# GRADING AND EROSION CONTROL PLANS

## SPRINGS AT WATERVIEW

EL PASO COUNTY, STATE OF COLORADO

PROJECT SPRINGS AT WATERVIEW  
SHEET TITLE 0102.1 - GEC-DETAIL - 3 GENERAL DETAILS  
FROM \_\_\_\_\_ TO \_\_\_\_\_  
JOB NO. 0102.1 SHEET --- OF 7

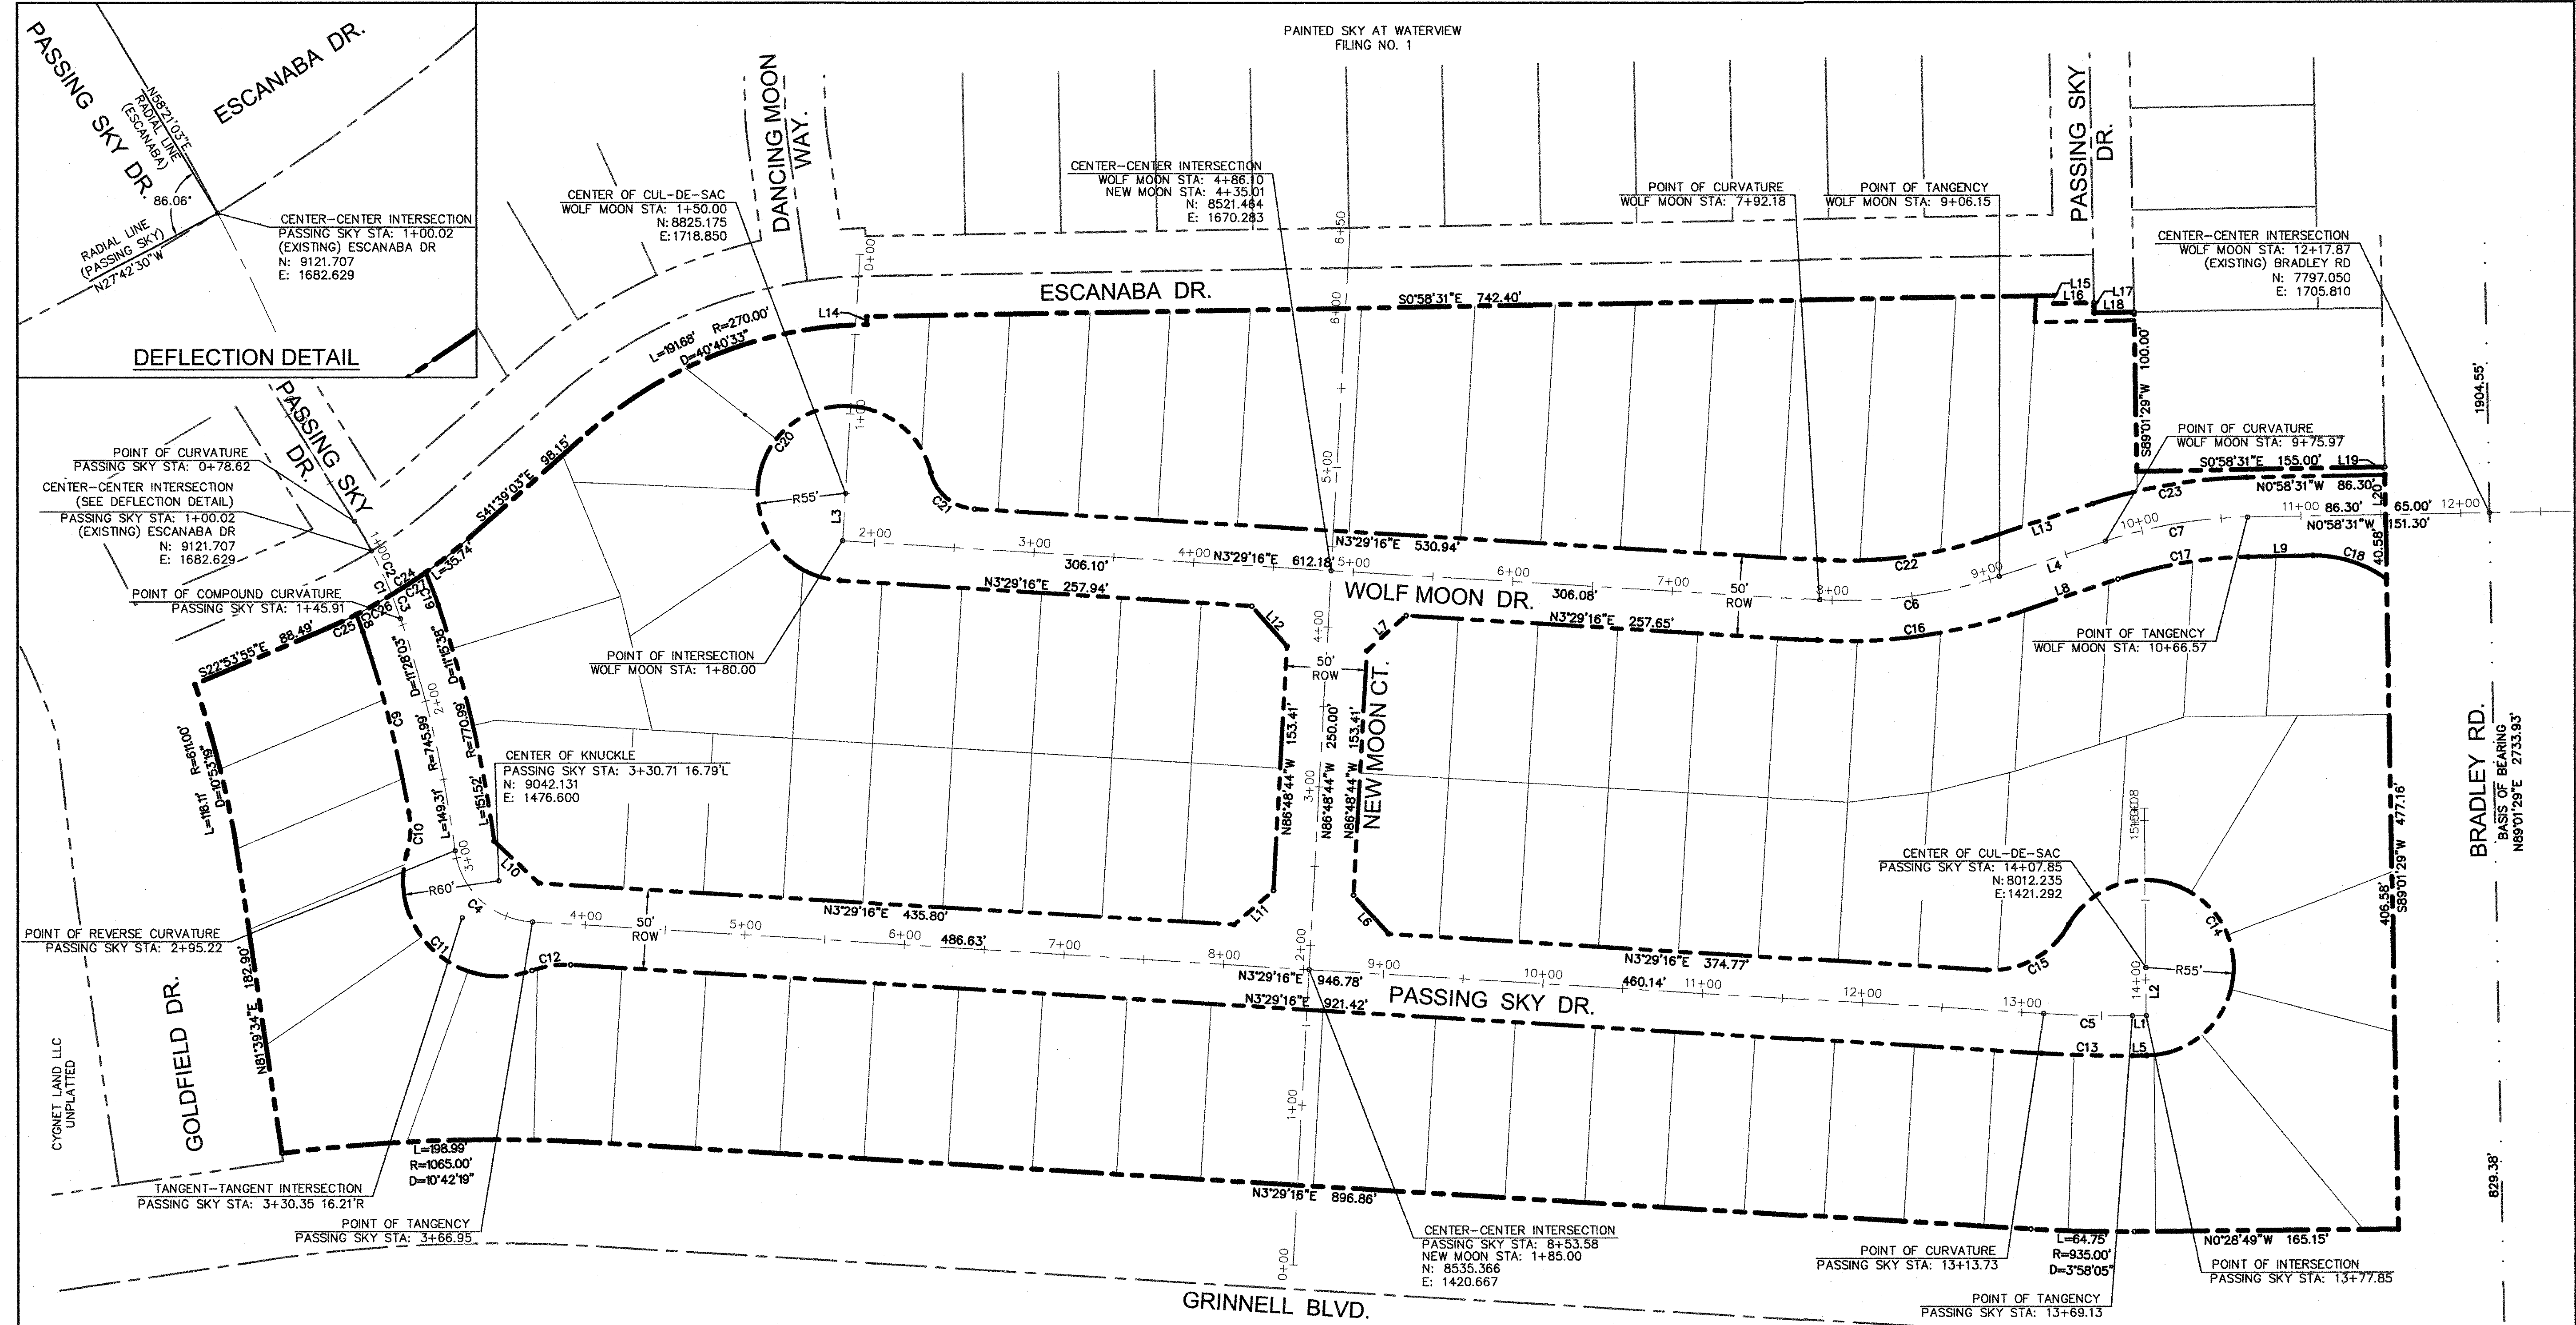
This sheet was not a part of the original approved GEC plan set. Remove or update the sheet index in the cover sheet.

Sheet was included in plan approved 10.16.18 and appears on the sheet index.
